Our Case Number: ABP-317660-23

Re: Bus Connects Kimmage to City Centre core bus corridor scheme
Kimmage, Dublin

KIMMAGE TO CITY CENTRE CORE BUS CORRIDOR SCHEMELANDSCAPING AND URBAN REALM

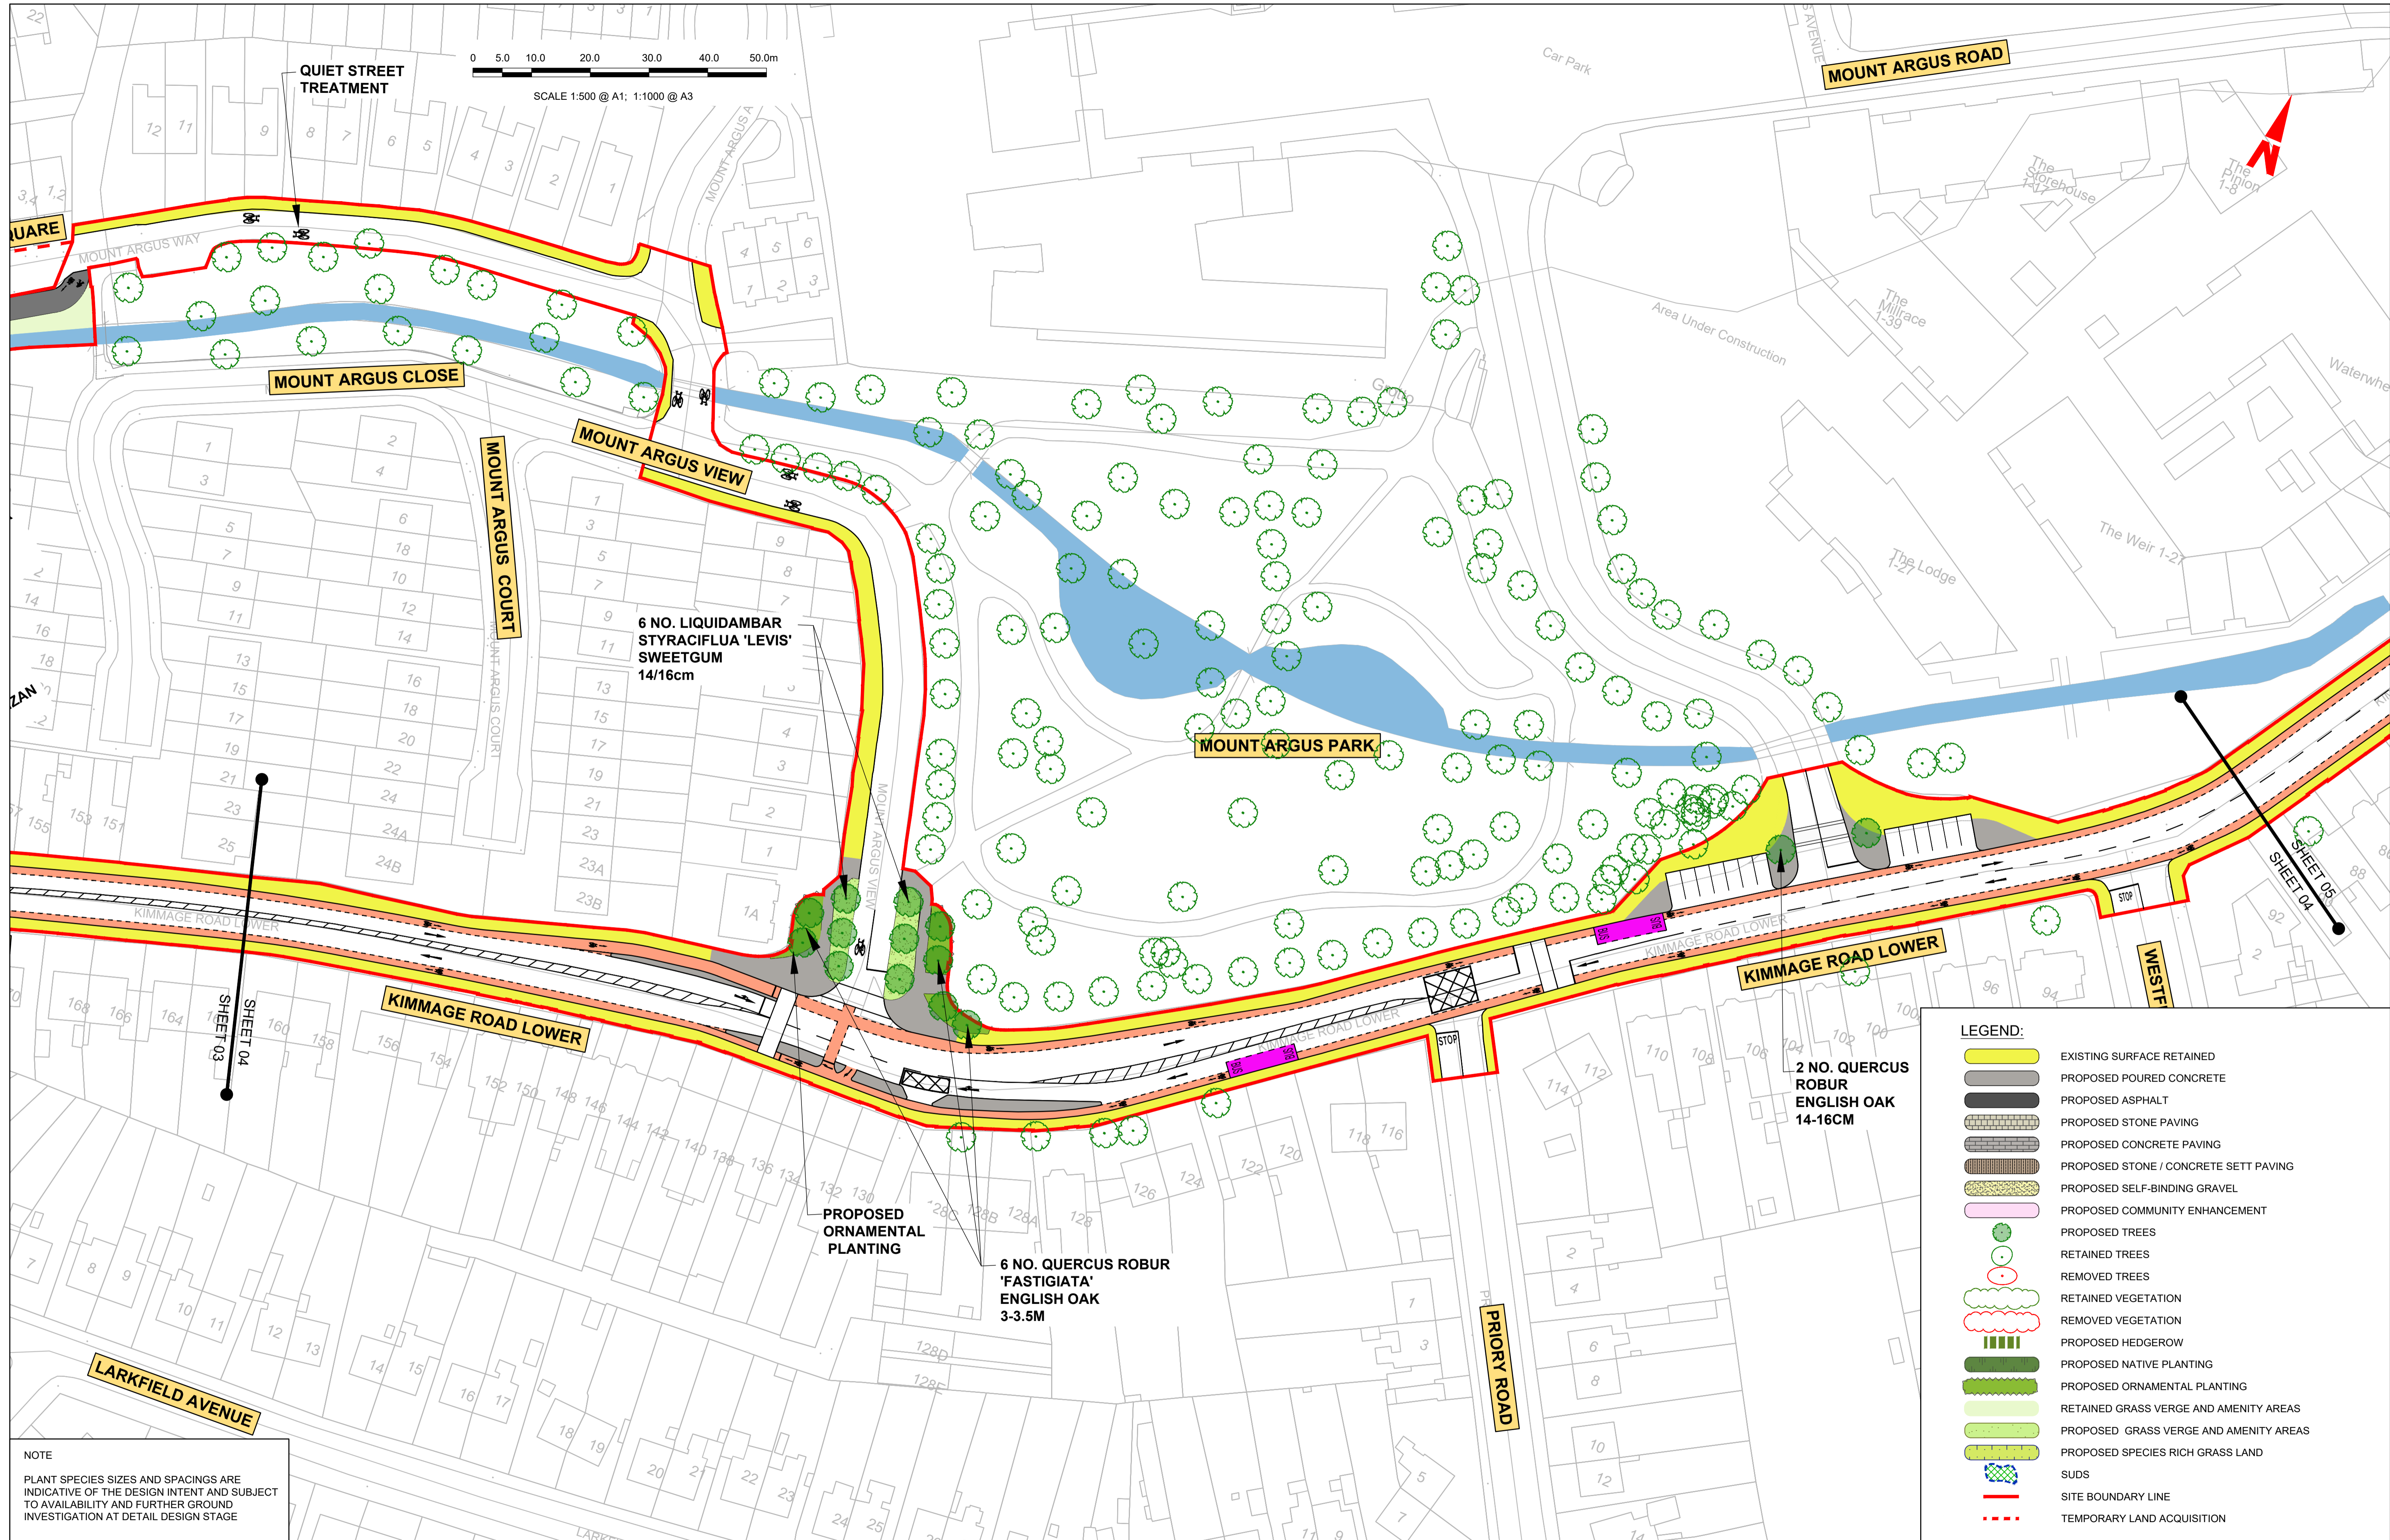
BCIDD-ROT-ENV_LA-0011_ML_00-DR-LL-0003 Sheet 3 of 14 (general note to entire route)

There are existing telephone / light / sign poles which are poorly located which prevent two way traffic due to minimum distance between poles & boundary wall to footpath. It is an particularly an issue when meeting with prams or wheelchairs The concrete foot paths have been shown as yellow indicating no amendment to locations. These poles should be repositioned while the improvement works are underway. Suggest survey carried out to determine locations to full layout (sheet 1 – 14) and correct amend within layouts. See below photo for example

BCIDD-ROT-ENV_LA-0011_ML_00-DR-LL-0003 Sheet 3 of 4

There are less tree provisions being provided to Lower Kimmage Road / Sundrive Rd road junction than was shown in the preferred route PDF issued previously. Suggest increasing.

BCIDD-ROT-ENV_LA-0011_ML_00-DR-LL-0003 03 Sheet 3 of 14

There is an opportunity to provide high quality amenity space to Sundrive Road / Lower Kimmage junction and surround. Granite / stone paving should be used to promote foot traffic / community sustainability and more ambitious public landscaping / street furniture should be provided.

Programme Title BUSCONNECTS DUBLIN CORE BUS CORRIDORS INFRASTRUCTURE WORKS				
Drawing Title KIMMAGE TO CITY CENTRE CORE BUS CORRIDOR SCHEME LANDSCAPING AND URBAN REALM				
Drawing File Name BCIDD-ROT-ENV_LA-0011_ML_00-DR-LL-0004	Sheet Number 04 of 14	Status A	Rev M01

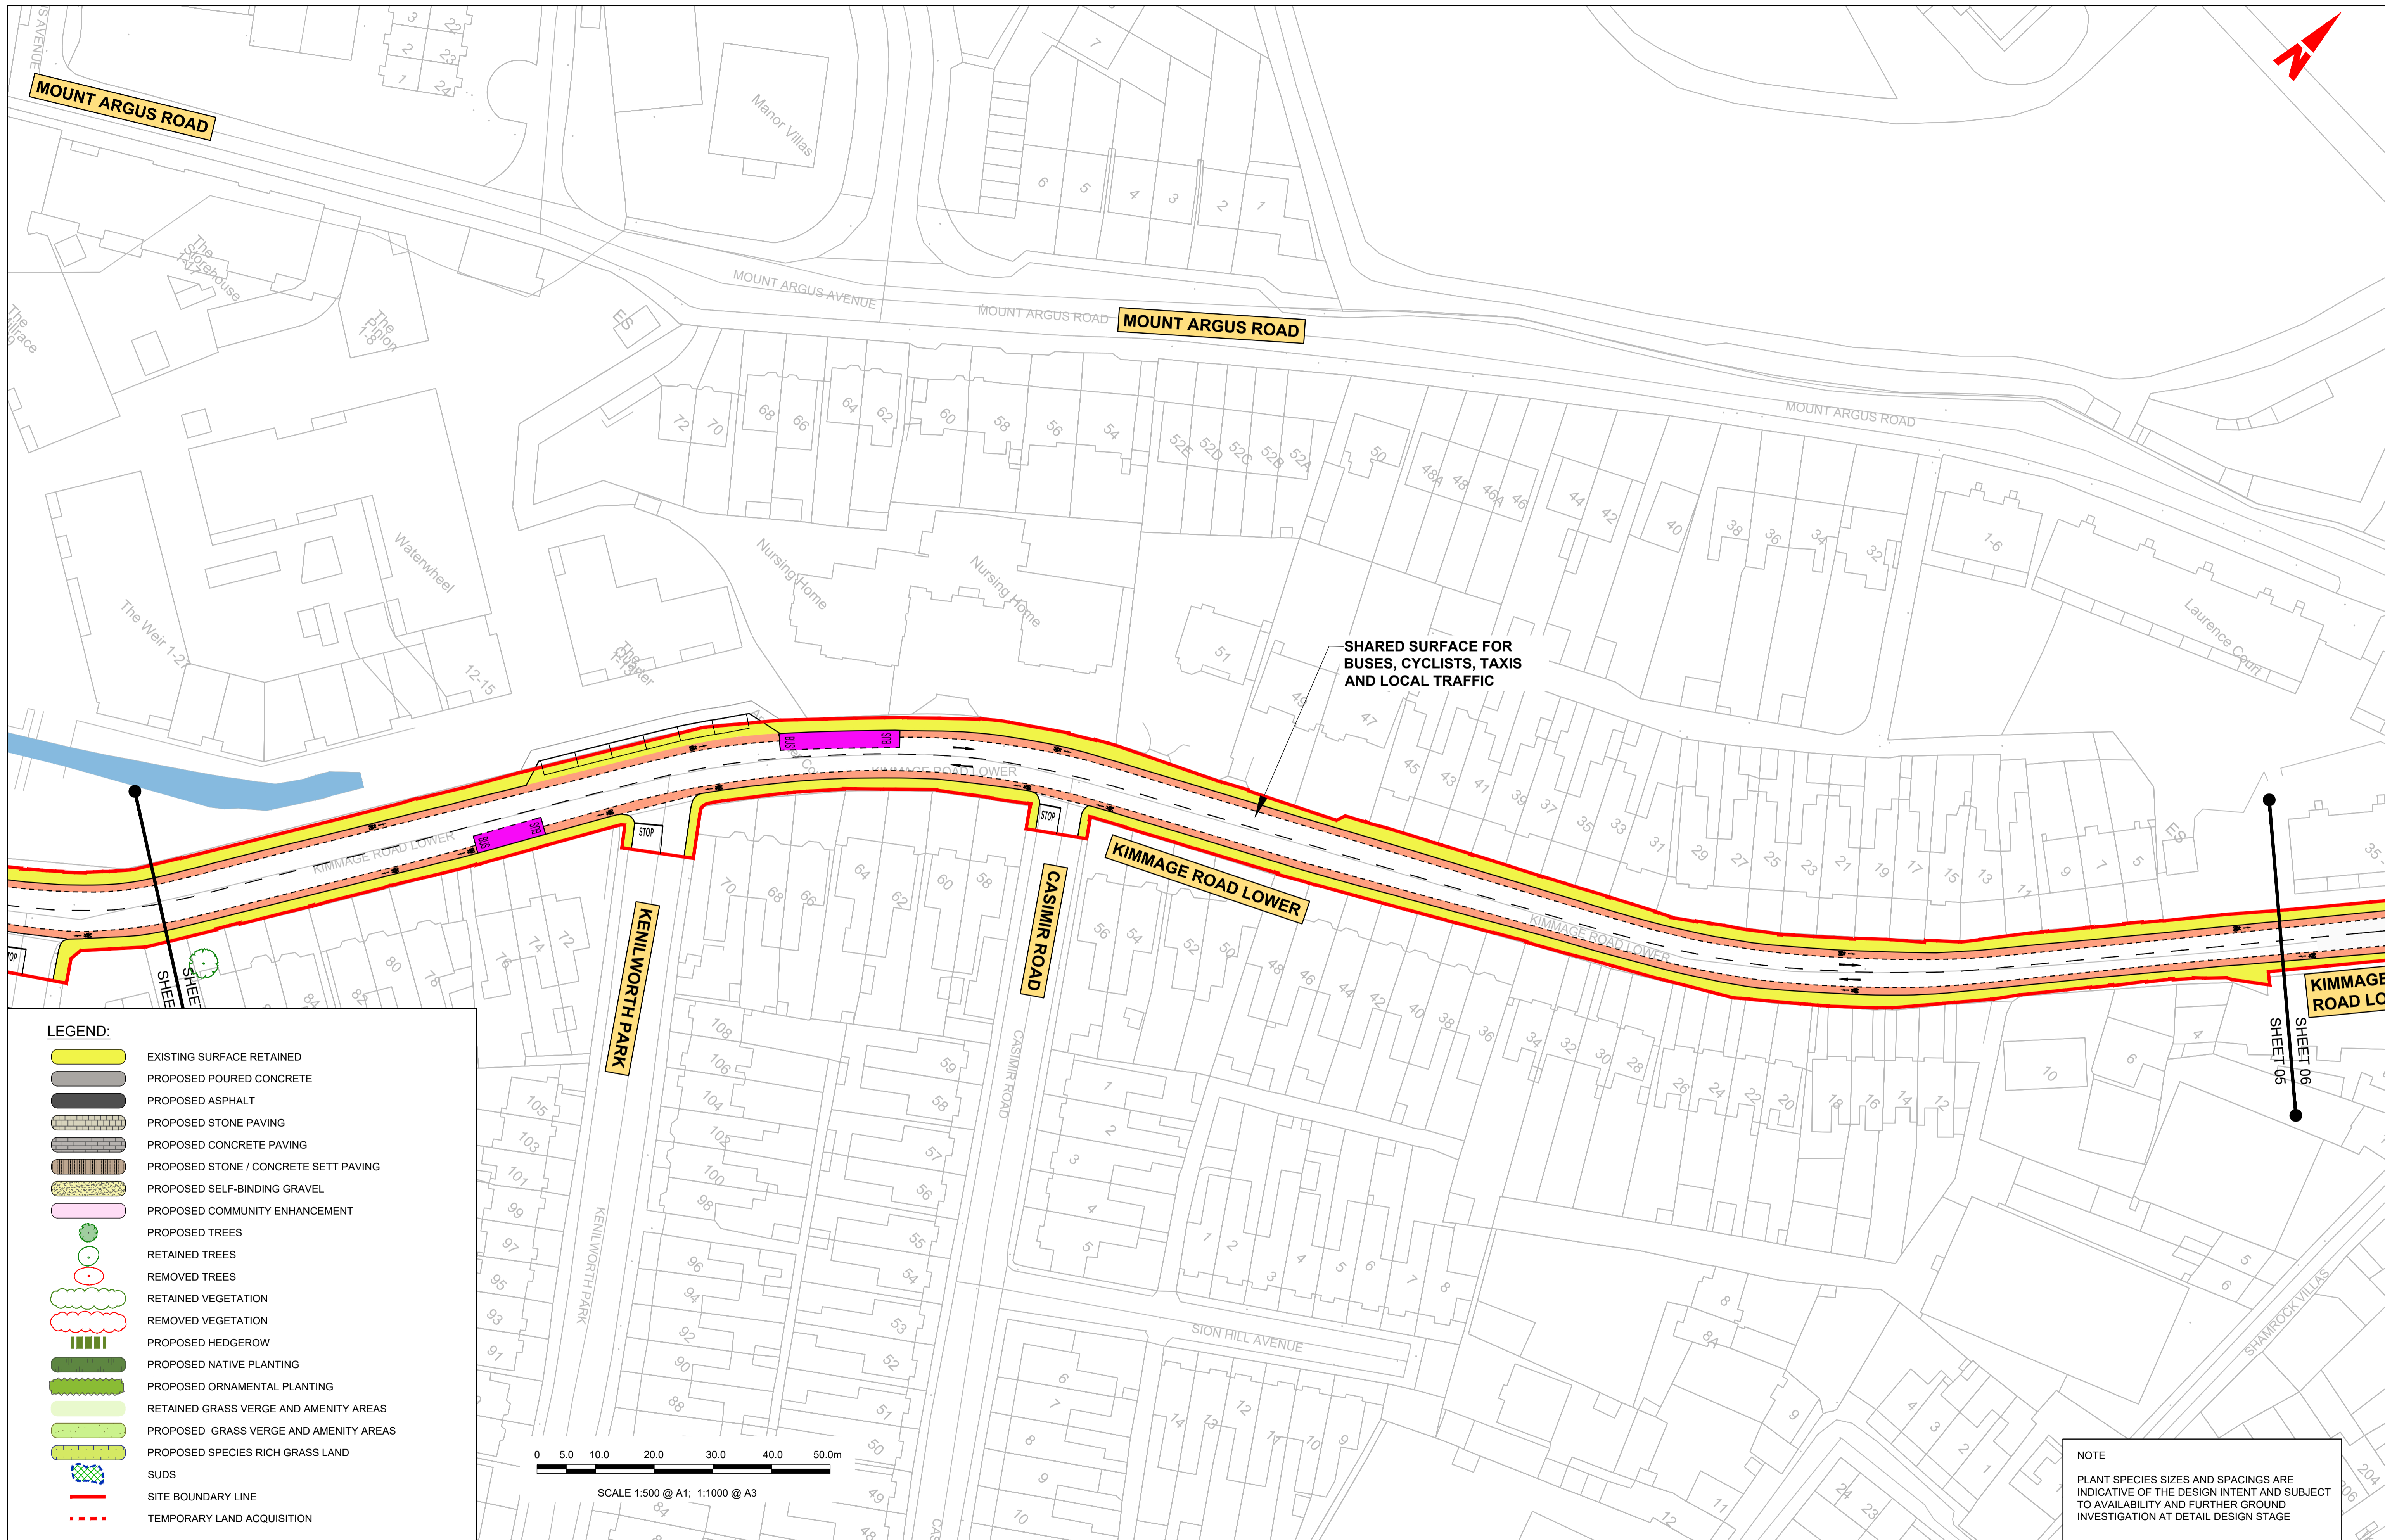
BCIDD-ROT-ENV_LA-0011_ML_00-DR-LL-0004 Sheet 4 of 14 (general note to entire route)

There are existing telephone / light / sign poles which are poorly located which prevent two way walking traffic due to minimum distance between poles & boundary wall to the footpath. The concrete foot paths have been shown as yellow indicating no amendment to locations. This poles should be repositioned while the works are underway. These poles should be repositioned while the

Improvement works are underway. Suggest survey carried out to determine locations to full layout (sheet 1 – 14) and correct amend within layouts. See below photo for example.
